**WEST SUSSEX COUNTY COUNCIL
STRATEGIC PLANNING CONSULTATION**

SUBJECT: LU/136/14/HH -Drop kerb & vehicular access. This application may be determined by Littlehampton Town Council under delegated powers

34, Wick Street, Littlehampton, West Sussex, BN17 7JH

Ref 2

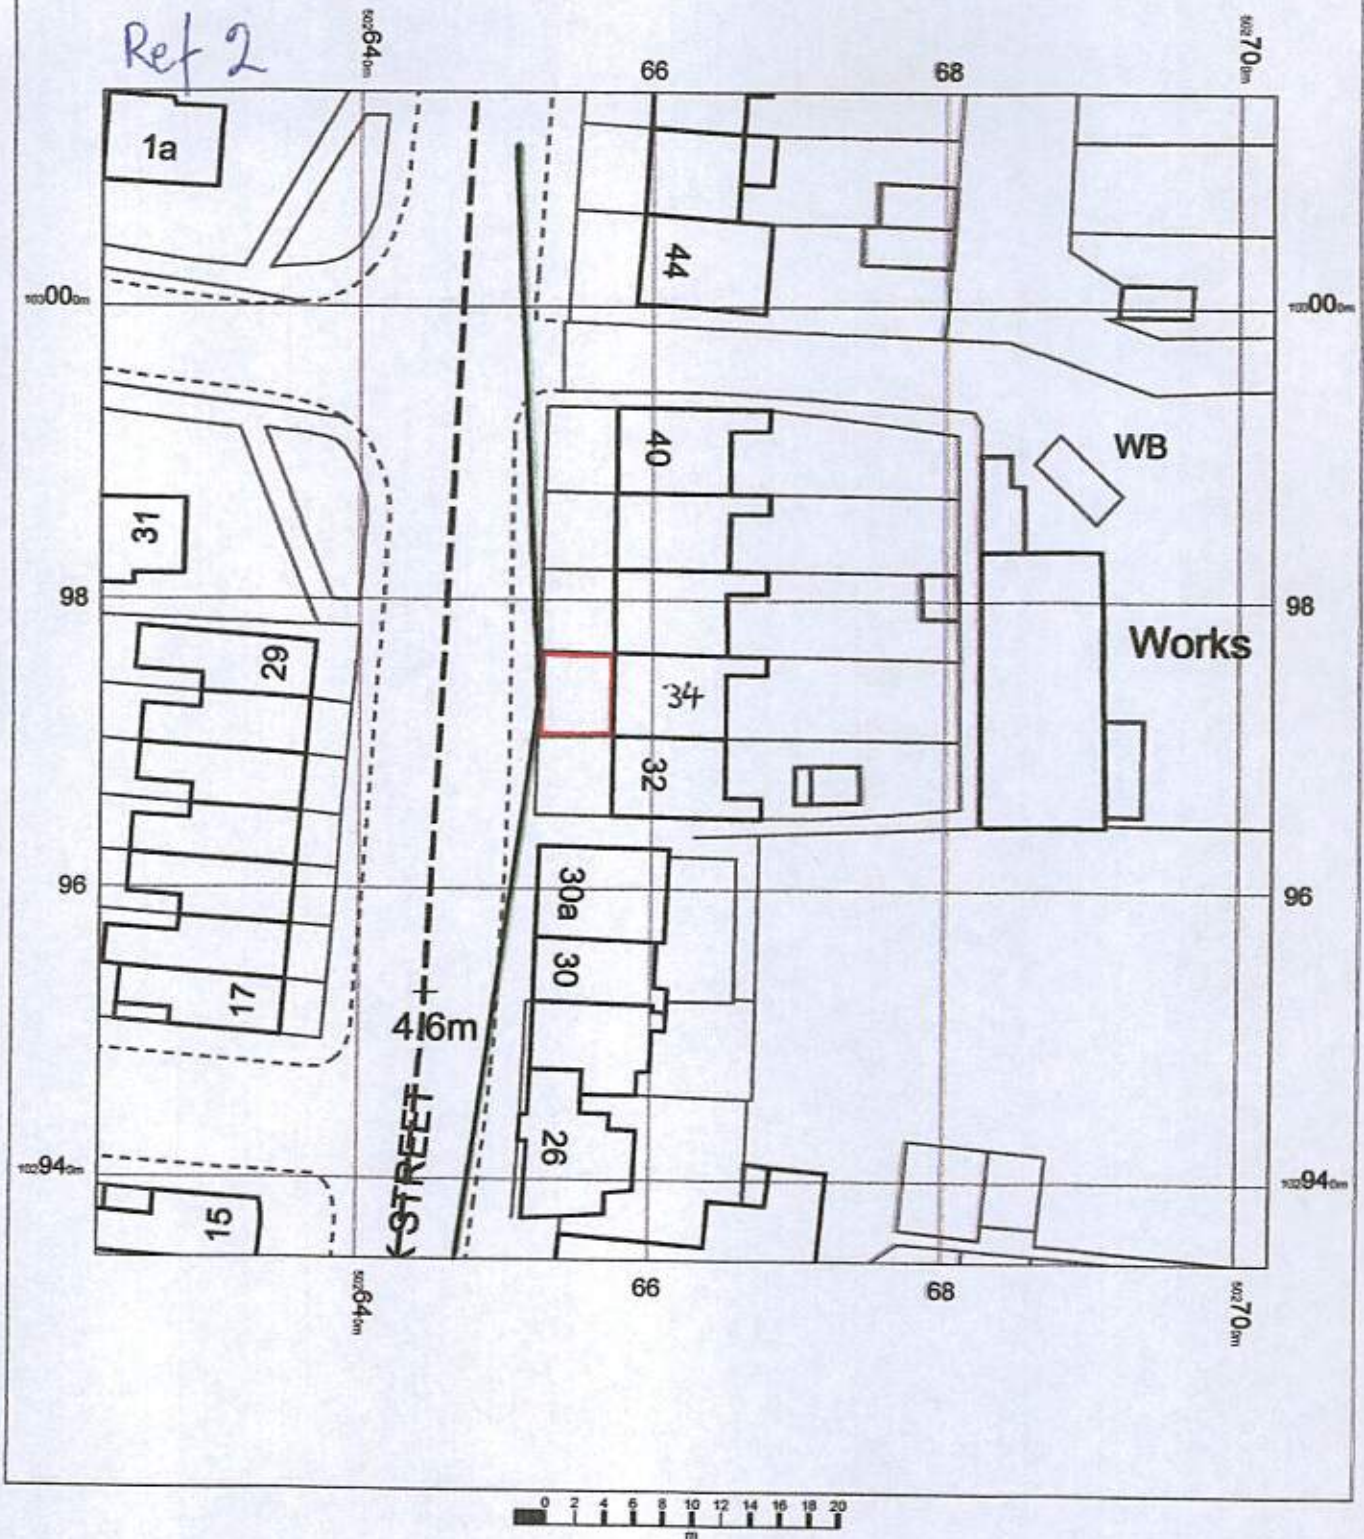
The proposed crossover to access the driveway will require visibility splays of 2m for pedestrians, as shown on the proposed plans. This will require any proposed planting to be no higher than 0.6m above the ground level and any existing foliage to be maintained in order to safeguard the visibility splay.

A turn on site would be preferred, clearly though there is insufficient space to achieve this. However other properties have similar arrangements and balanced against this is the benefit of providing an opportunity to remove potentially two vehicles that would otherwise be parked on the highway in a location where the existing practice is on-street parking by residents of adjoining properties. This can result in a noticeable narrowing of the existing available carriageway space.

No concerns from the highway point of view. If the LPA are minded to approve this application a condition securing the new access and pedestrian visibility splays should be included.
